A1 Birtley to Coal House
Scheme Number: TR010031

Applicant's Response to ExA's Third Written
Questions

Rule Number:	Rule 8(1)(b)
Planning Inspectorate Scheme Reference	TR010031
Application Document Reference	Applicant's Response to ExA's Third Written Questions
Author:	A1 Birtley to Coal House Project Team, Highways England

Version	Date	Status of Version
Rev 0	9 June 2020	For Issue

Gantry Details

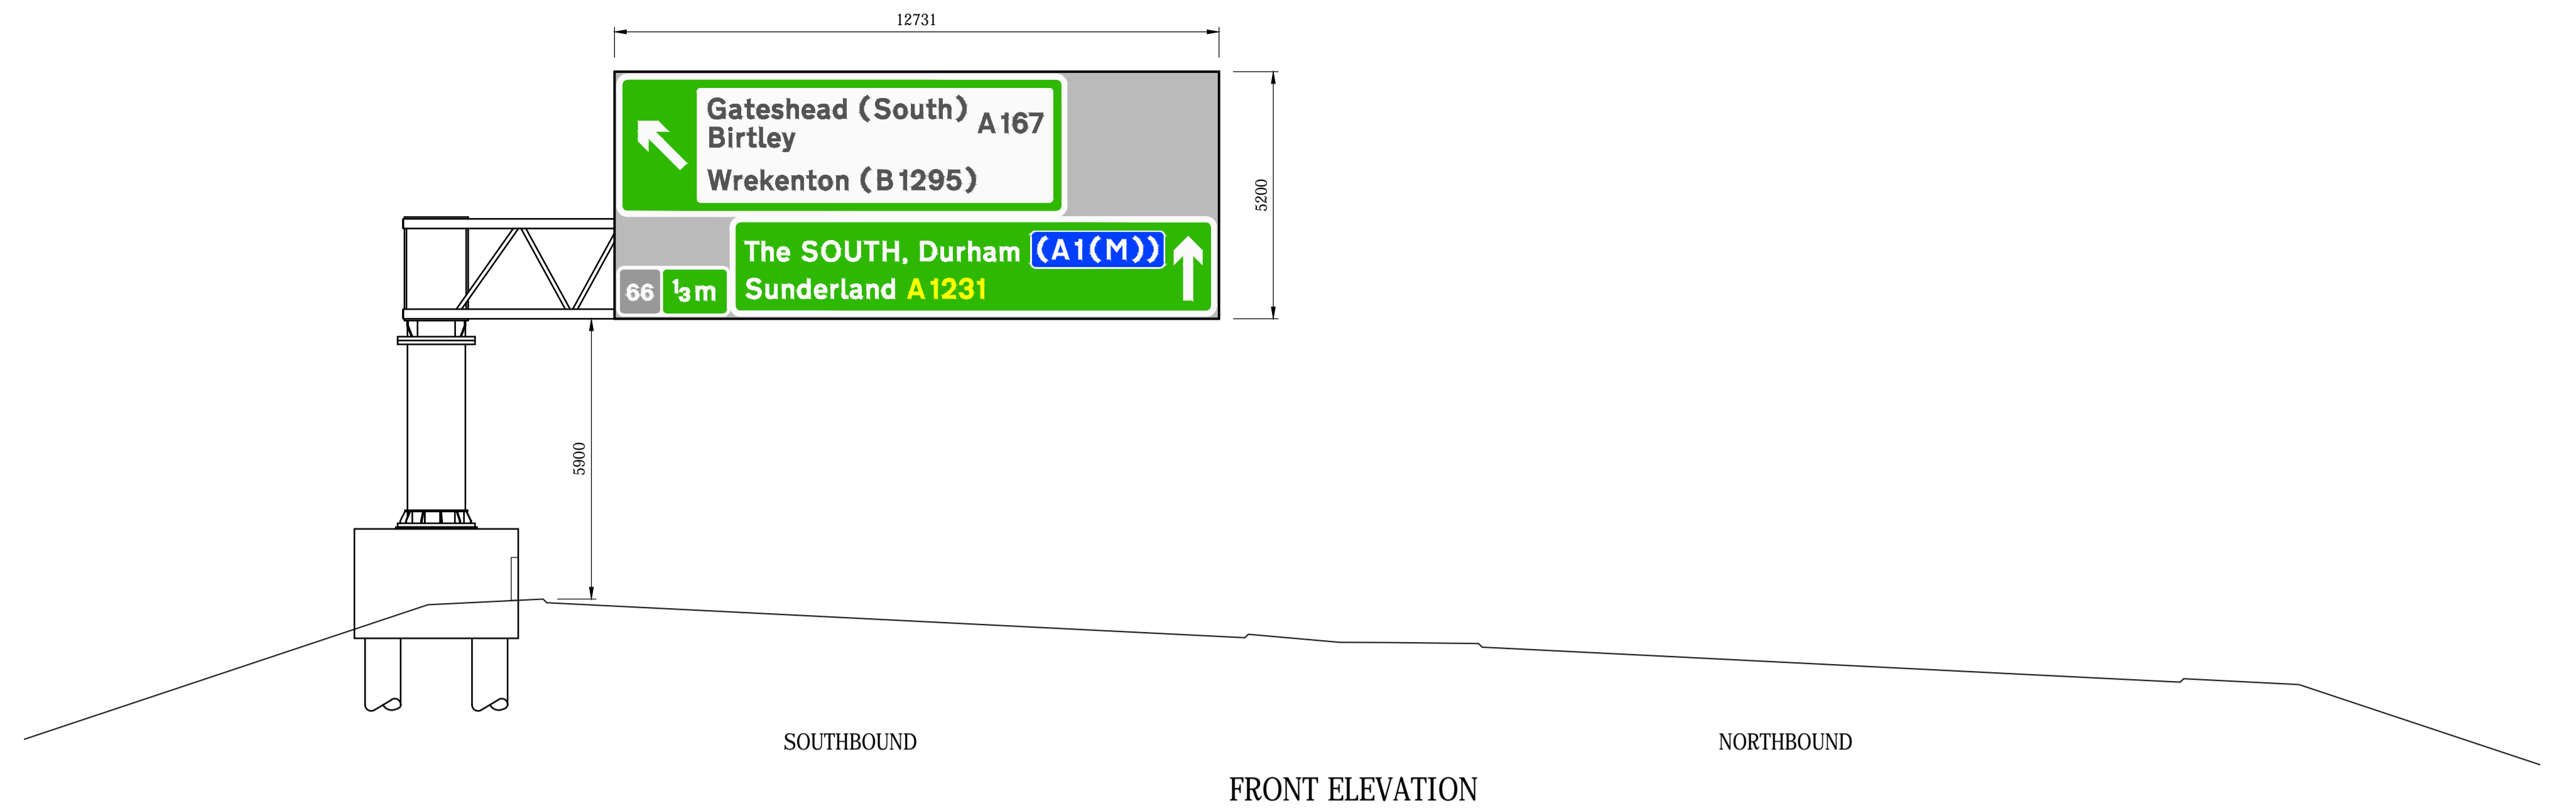
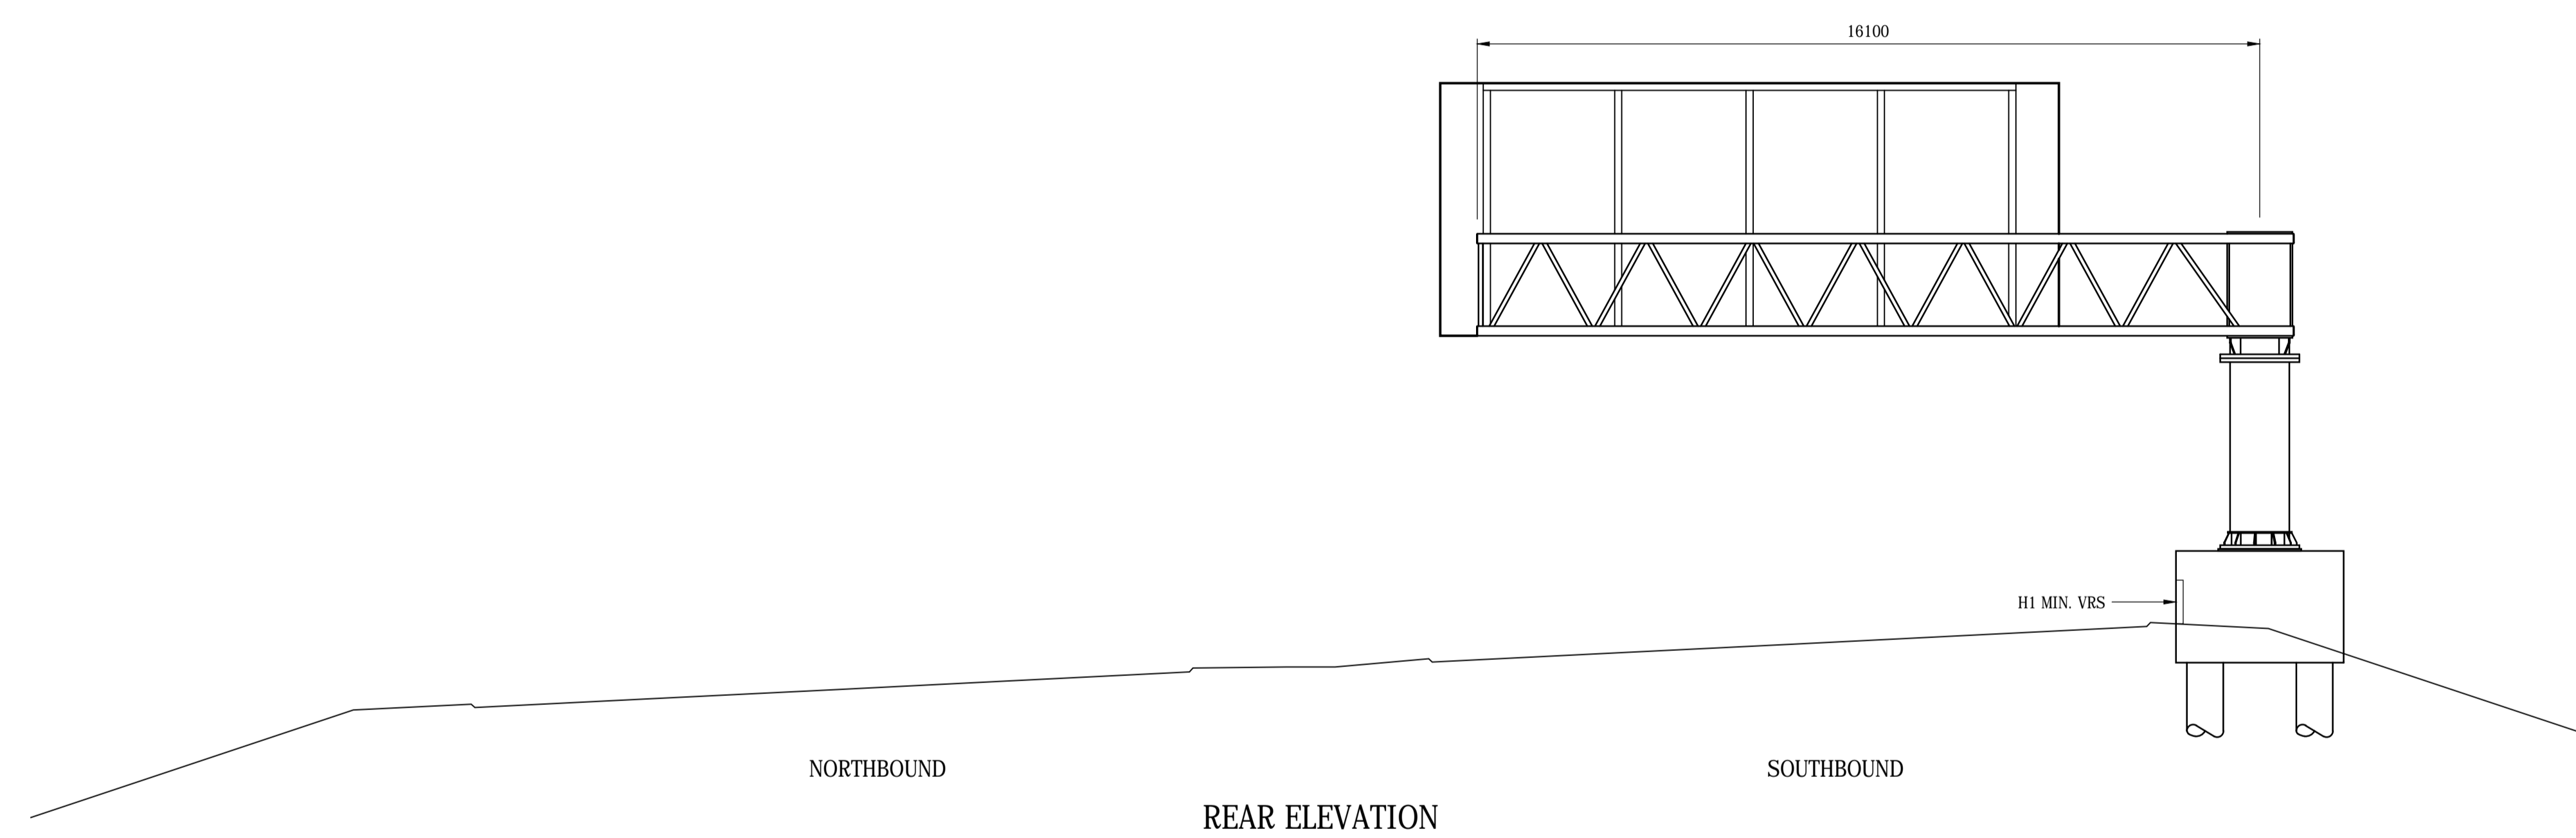
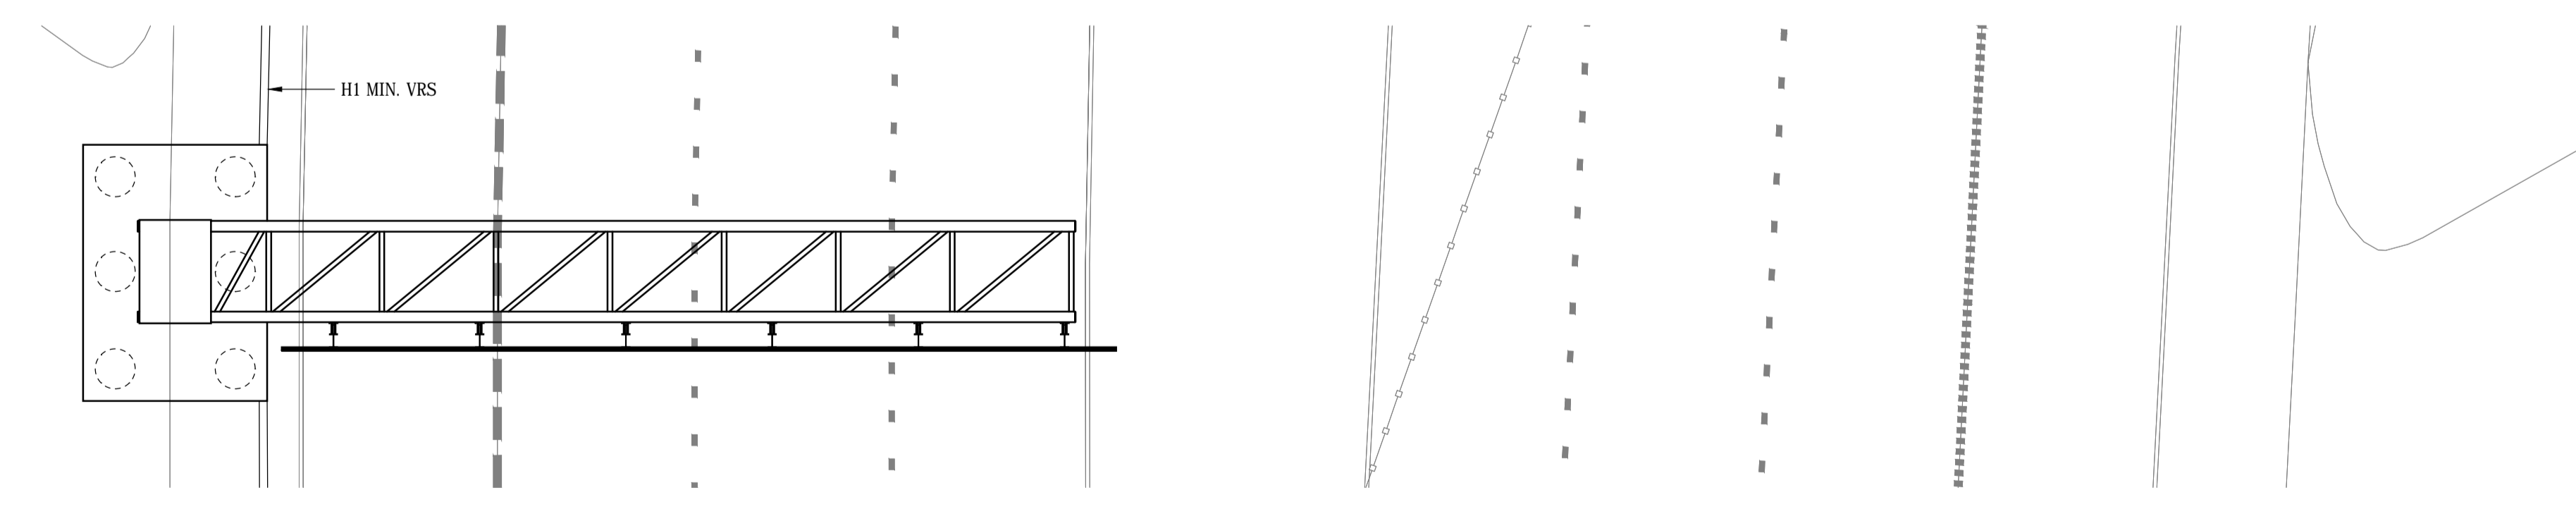
3.6.3	Applicant	<p>At Deadline 5 the Applicant [REP5-010] states that the super span gantries could be replaced with gantries that span one carriageway only (where signage is required in one direction). The Applicant goes on to state that there would be other implications arising from this in relation to future maintenance activities leading to disruption for road users and potential impacts upon the alignment design resulting in adjustment to the central reserve and adjacent lane widths.</p>	<p>a) The approach to the use of single span gantries in substitution for super span gantries would be as follows:</p> <p><u>Northbound</u></p> <p>Were the proposed super span gantry located at Chainage 14325 to be modified to a single span gantry, there would likely be a marginally greater awareness of the Angel of the North. However, a subsequent gantry at Chainage As a result, there would be a very marginal improvement in the views to the Angel of the North from changing the gantry at chainage 14325</p>

Ref No:	Question to:	Question: Landscape and Visual	Response:
		<p>a) Please can the Applicant provide further details of the feasibility and effects of using gantries that span one carriageway only, particularly for those gantry chainage locations that would interrupt views of the Angel of the North?</p>	<p>only.</p> <p>Were the proposed super span gantry located at Chainage 14115 to be modified to a single span gantry, there would be little perceptible change in the anticipated views of the Angel of the North, with the overhead sign briefly interrupting the view northwards. The view would not be interrupted by the central stanchion. As a result, there would be no improvement in the views to the Angel of the North.</p> <p>Were the proposed super span gantry located at Chainage 13515 to be modified to a single span gantry, there would be marginal improvement in the uninterrupted view towards the Angel of the North. However, vegetation in the existing landscape and associated with Eighton Lodge currently screens the views of the sculpture, with the stanchion to the gantry within the central reserve introducing a new vertical element into the view from the A1 northwards. As a result, there would be a very marginal improvement in the views towards the Angel of the North, albeit screened by vegetation.</p> <p>Were the proposed super span gantry located at Chainage 13375 to be modified to a single span gantry, there would be a marginal deterioration in the view, the stanchion to the gantry within the central reserve introducing a vertical element into the view from the A1 northwards. This would have the effect of potentially interrupting views of the Angel of the North. However, vegetation in the existing landscape and associated with Eighton Lodge currently screens the views of the sculpture. As a result, there would be no perceptible change in the views towards the Angel of the North, the sculpture all but screened by existing vegetation.</p> <p>Were the proposed super span gantry located at Chainage 12870 to be modified to a single span gantry, there would be a marginal deterioration in the views towards the Angel of the North. The central stanchion interrupting views for northbound travelers shortly after the verge mounted stanchion would have interrupted the view, whereby in its current form, the verge mounted stanchion would remain outside of the line of sight towards the Angel of the North. As a result, there would be a marginal deterioration in the views to the Angel of the North.</p> <p><u>Southbound</u></p> <p>Were the proposed super span gantry located at Chainage 11150 to be modified to a single span gantry, there would be a marginal deterioration in the views towards the Angel of the North. This would arise as a result of the central stanchion briefly interrupting the view, whereby in its current form the verge mounted stanchion would remain outside of the line of sight towards the Angel of the North. As a result, there would be a marginal deterioration in the views to the Angel of the North.</p> <p>Were the proposed super span gantry located at Chainage 12450 to be modified to a single span gantry, there would be no perceptible change in the views of the Angel of the North. The</p>

Ref No:	Question to:	Question: Landscape and Visual	Response:
			<p>central stanchion would remain outside of the line of sight towards the Angel of the North. As a result, there would be no perceptible change in the views towards the Angel of the North, the sculpture also being partially screened by existing vegetation.</p> <p>Summary</p> <p>Should the currently proposed super span gantries be installed in a single span form, it is expected that the likely improvements or deterioration in the views towards the Angel of the North would be marginal. Where the central stanchions would interrupt views, there would likely be a marginal deterioration in the view. However, in longer distance views from the south, and where the adoption of a single span design would omit a feature that would have otherwise interrupted views of the Angel of the North, there would be a marginal improvement in the views experienced by the users of the A1. On balance and should the single span gantry design approach be adopted, the conclusions of the assessment of landscape and visual effects outlined in Chapter 7: Landscape and Visual [APP-028] of the ES would not be affected.</p> <p>The fact that the assessed impacts of the Scheme including single span gantries would not be altered has to be balanced against other considerations.</p> <p>With regard to the feasibility and effects of mounting gantry supports in the central reserve which was outlined previously in Table 1, 2.0.8 in the Applicant's response to Deadline 4 Submissions [REP5-010], the supports and foundations being located in the central reserve will require lane closures/traffic management. This would be necessary to gain future access to enable routine maintenance activities to be carried out in a safe manner, resulting in disruption for road users. Even at relatively infrequent maintenance events, the risk to operatives is a key point of difference. It is not merely a question of inconvenience to road users and operatives – a central reserve gantry support is inherently less safe for those who work on Highways England's roads.</p> <p>In addition, the introduction of gantry supports in the central reserve is likely to impact the alignment design resulting in adjustment and widening of the central reserve, adjacent lane widths and associated repositioning of the adjacent carriageways. This is due to the provision of potentially larger foundations and column supports as the supports within the central reserve will need to be designed for the effects of vehicular collision/impact loading. Further detailed assessment would be required to determine the magnitude of the effects and corresponding impacts.</p> <p>Gantry SG004 (Chainage 12450), Gantry SG005 (Chainage 12870), SG006 (Chainage 13515), SG008 (Chainage 14325), SG009 (Chainage 14115), SG011 (Chainage 13375) and SG014 (Chainage 11150) must remain a portal gantry as span >19m (they could potentially be changed from superspan to single span gantries with a support leg in the central reserve, but this will introduce the issues raised previously).</p>
